APPROVED
 Limited building only review
 Permit holder responsible for full compliance with the code

Slansca Residence

Addition

Drawing Name:
 Floor Plan

SHEET NO:	
A1.1

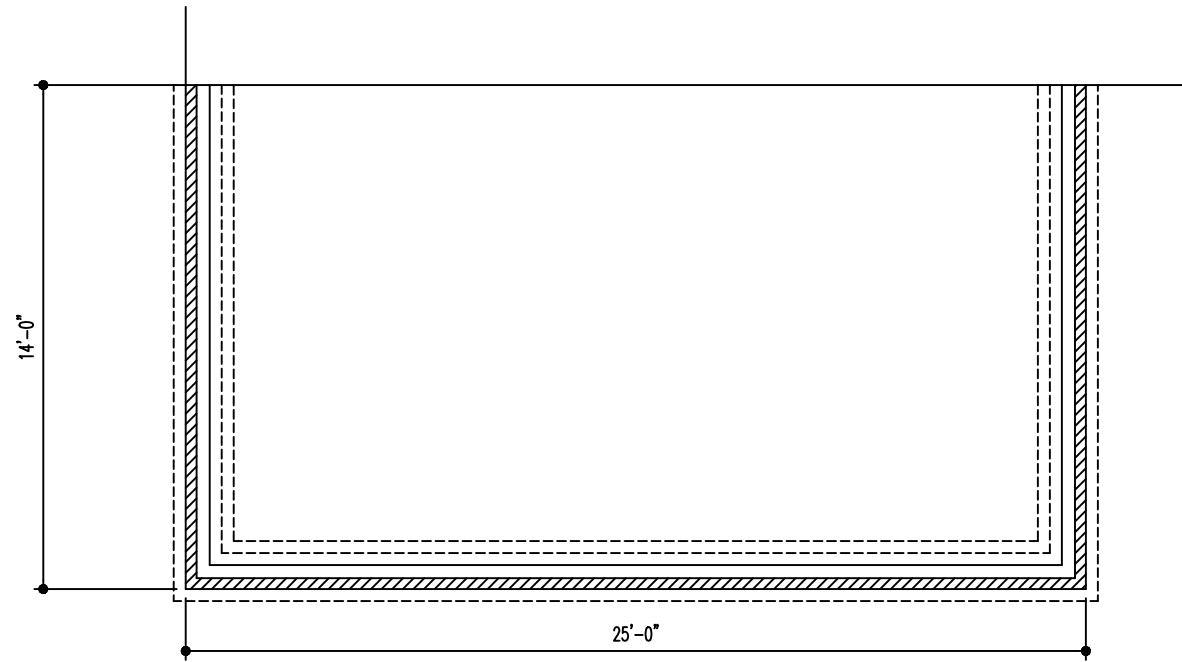
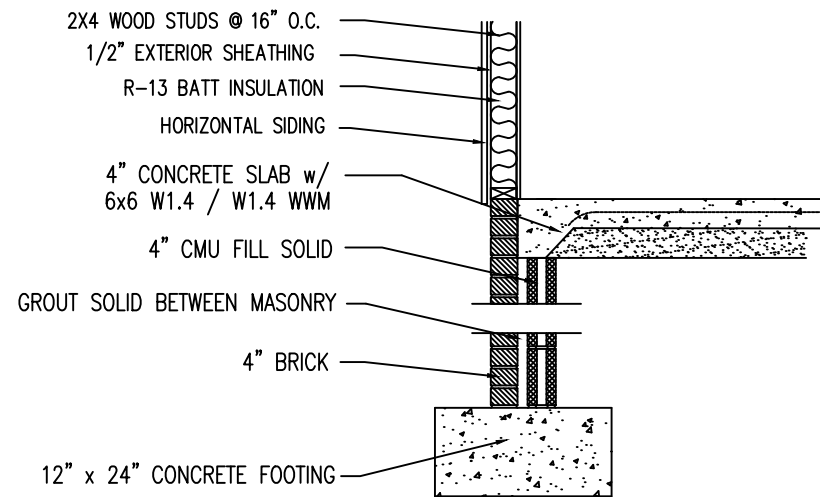
Must have R-10
Foam insulation in
foundation per code.
